RE: Presbyterian Hospital Main Drive Entry Relocation
Revise Grading and Drainage Plan
Engineer's Stamp Date 3-9-2017 (File: K15035F)

**RE: Presbyterian Hospital
Grading & Drainage Plan
File:K15D005F
Revised Plan Dated 11-17-2016**

**RE: Presbyterian Hospital
Grading & Drainage Plan
Stamp Date: 10-31-2016 (File:K15D005F)**

1 CONCRETE RUNDOWN
N.T.S.

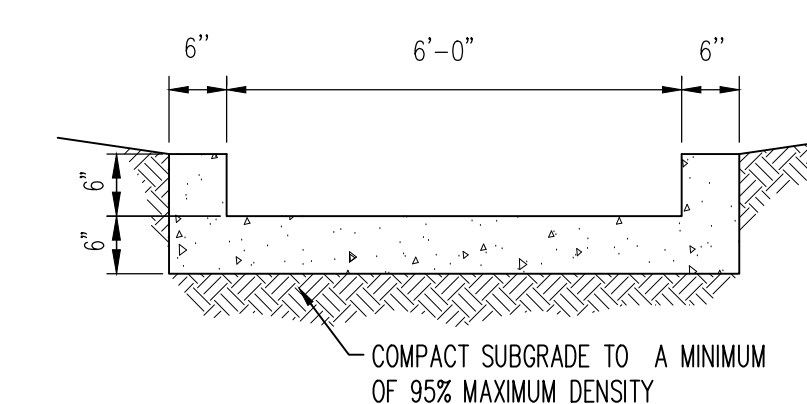
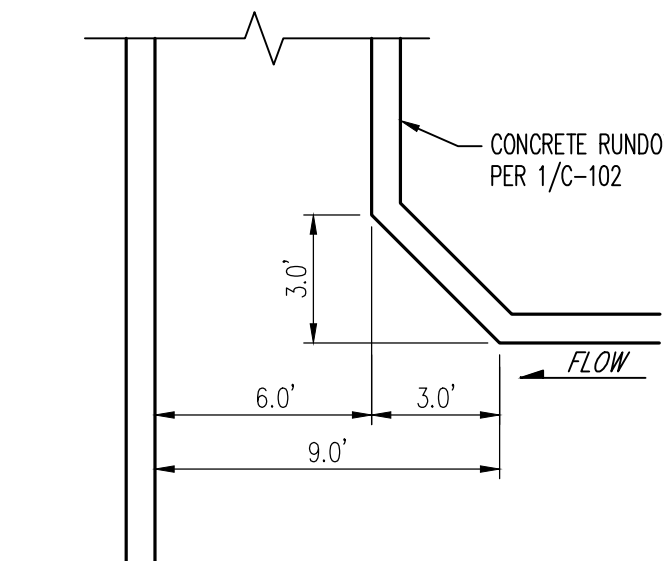
1. Consider incorporating a design element to reduce debris from reaching the underground water quality chambers to reduce the maintenance burden/clogging (not a requirement).
2. The improvements on Lots 3 and 4 do not include any water quality elements, except minimal capture in the parking islands. The large inlet upstream of the connection to the City's storm drain needs to be a water quality inlet. This can be accomplished with a hooded outlet or other similar low cost, yet reliable option.
3. Ensure that the Contractor has elevation data to set the bottom of the underground chambers. The final elevations should be included in the as-builts.
4. Provide calculations for the rundown and sidewalk culvert array capacity.

Prior to any grading on the site, an ESC Grading Permit must be processed (see attached), which is contingent on having an approved ESC Plan. Please attach a statement with the Permit that the above-mentioned conditions are acceptable to your client, as well as the calculations for Item 4.
